Post Hearing Submissions and Response to Deadline 4 Submissions
ELMESTHORPE PARISH COUNCIL
9th February 2024

1. Introduction

Figure 11.12: Night-time Views and Photomontages PVP 25

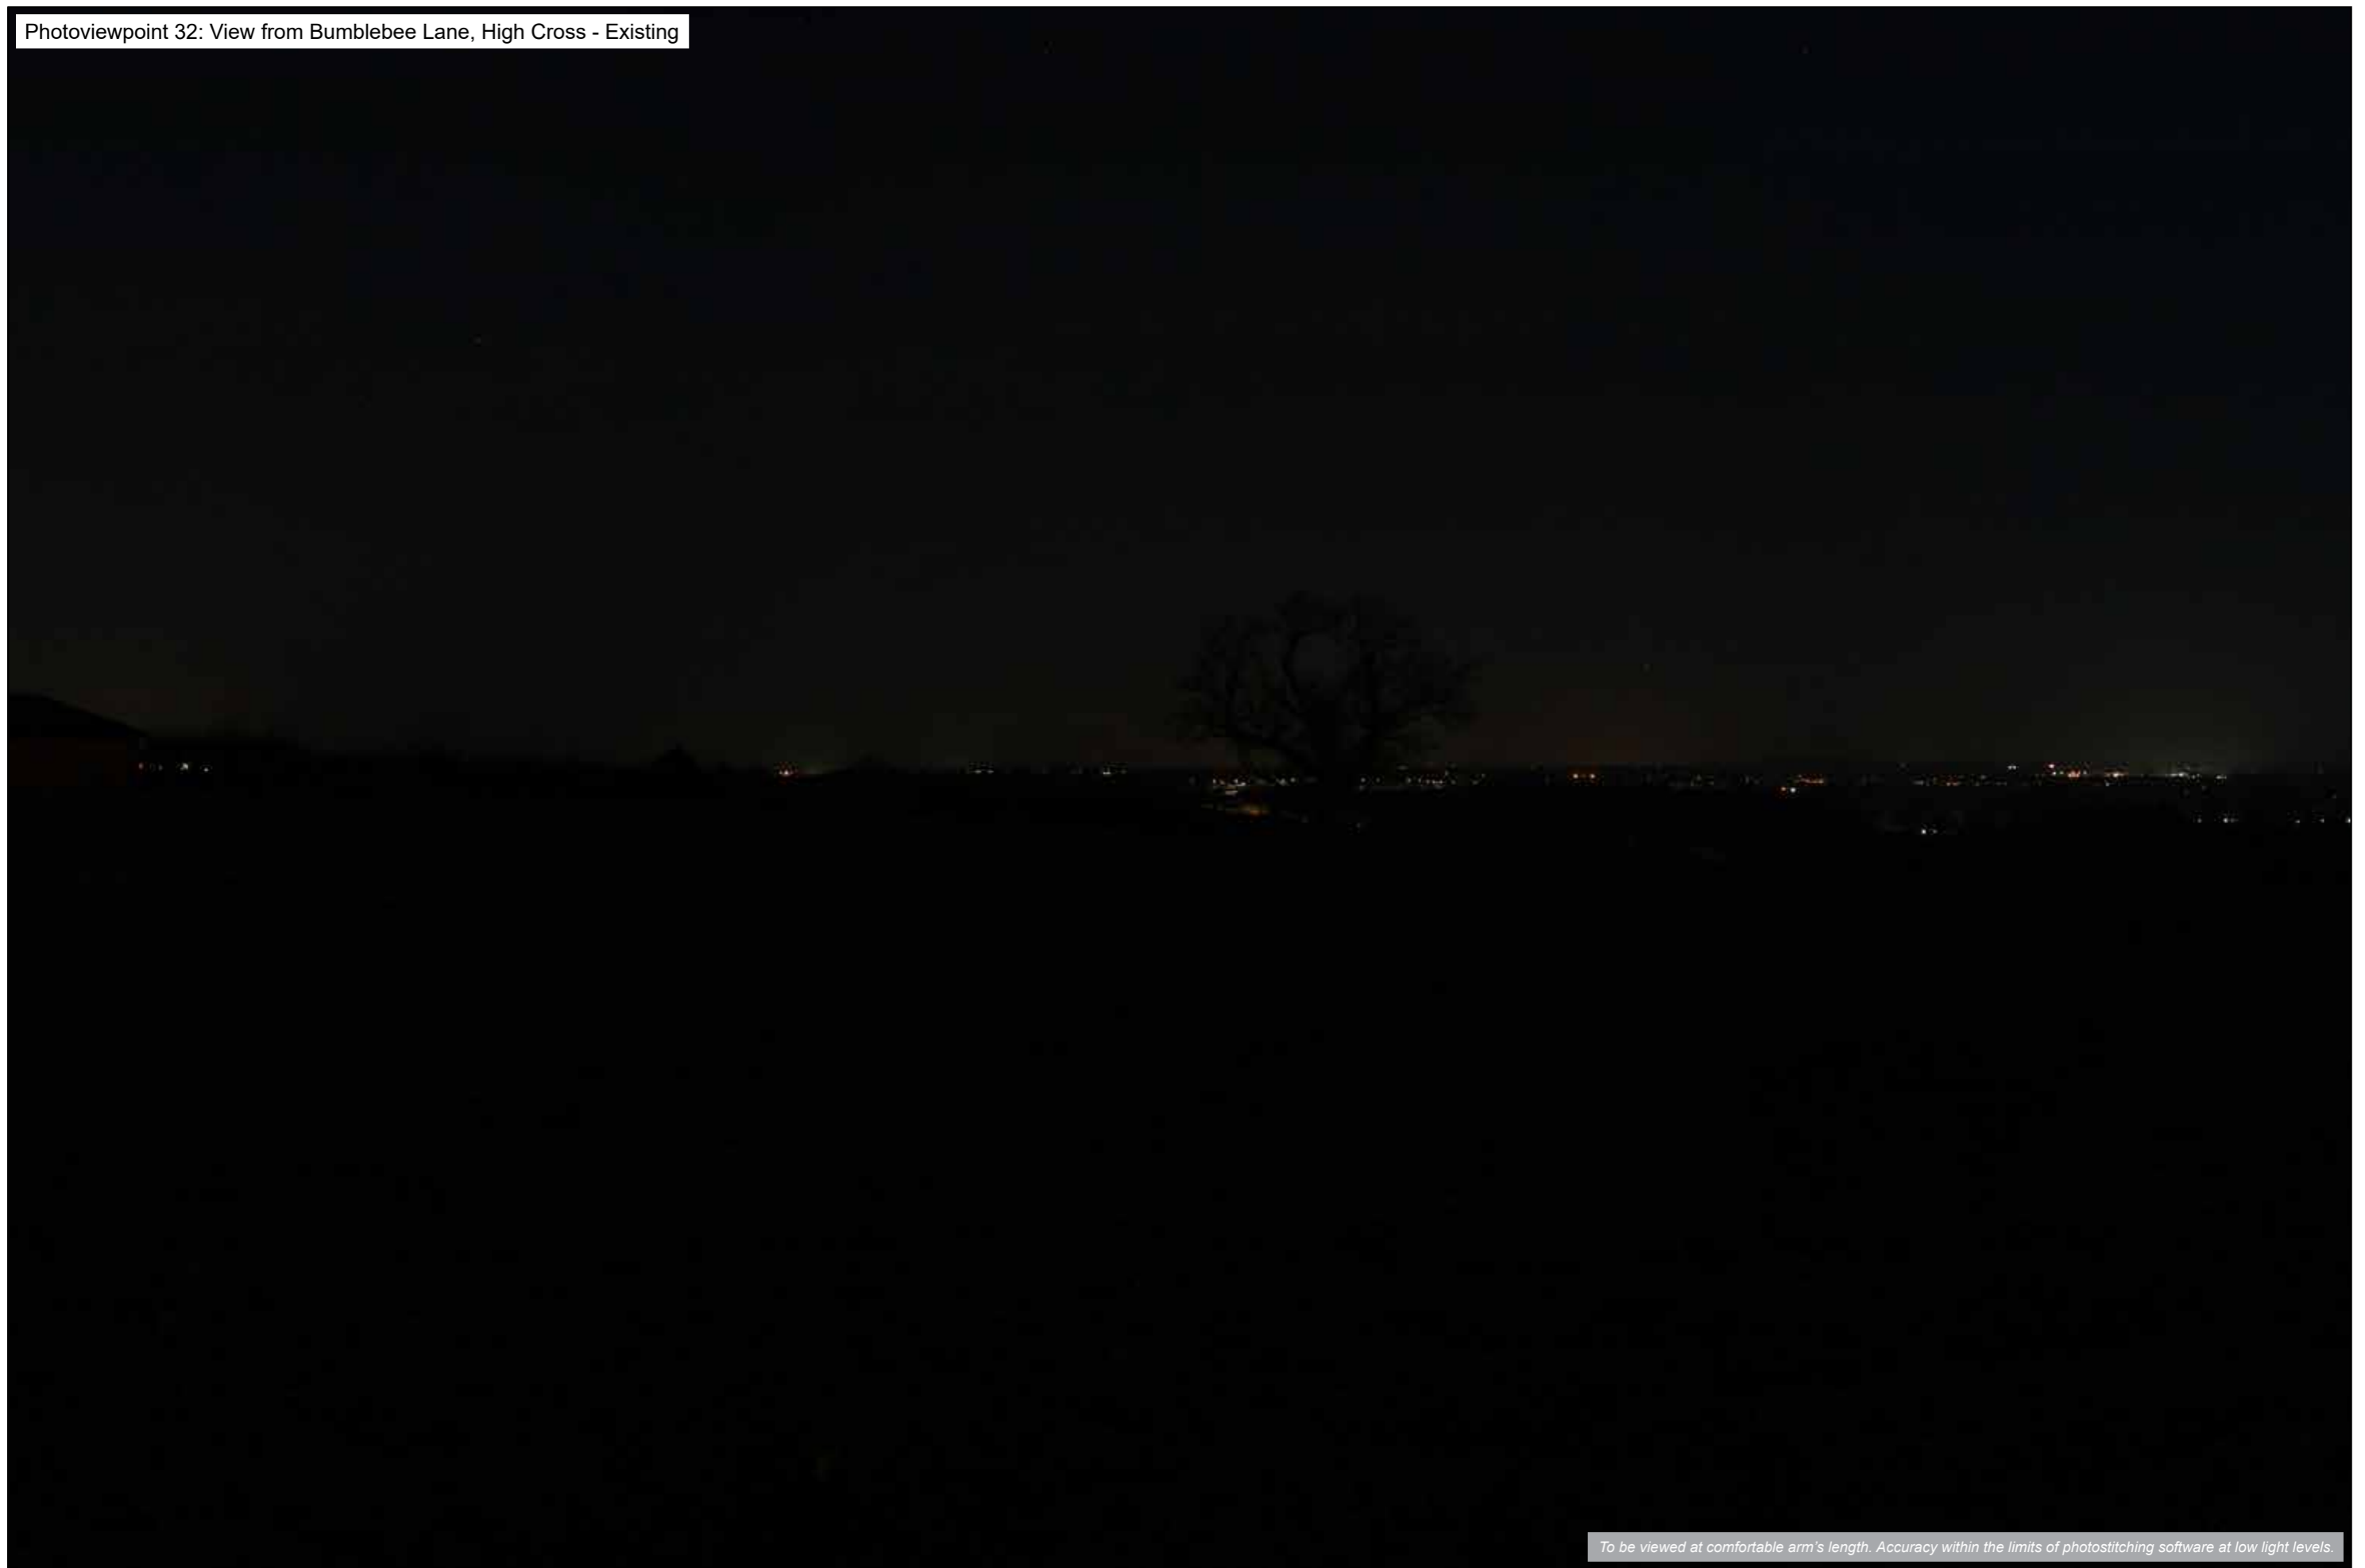
- 5.2. **6.3.11.12a Hinckley NRFI ES Figure 11.12 Night-time Views and Photomontages.** Photo Viewpoint 20 is the view from the M69 bridge B581, perhaps the most important and telling photo viewpoint of them all. This viewpoint doesn't correspond with the viewpoint 20 supplied at **6.3.11.16 Daytime Photomontages** (April 23) so it appears the applicant has opted to either change the angle of the photo and point the theoretical 'camera' away from the proposed site, or the wrong images have been included. Standing on the M69 bridge on the B581 as per the daytime photomontages viewpoint 20, would show significant change at night. With the current error or omission in information supplied, no-one is able to see the massive scale of change in the character of the area, or the effect of the lighting on those living just 300-350m from the site itself on Stanton Lane (B581/Burbage Common Road junction).
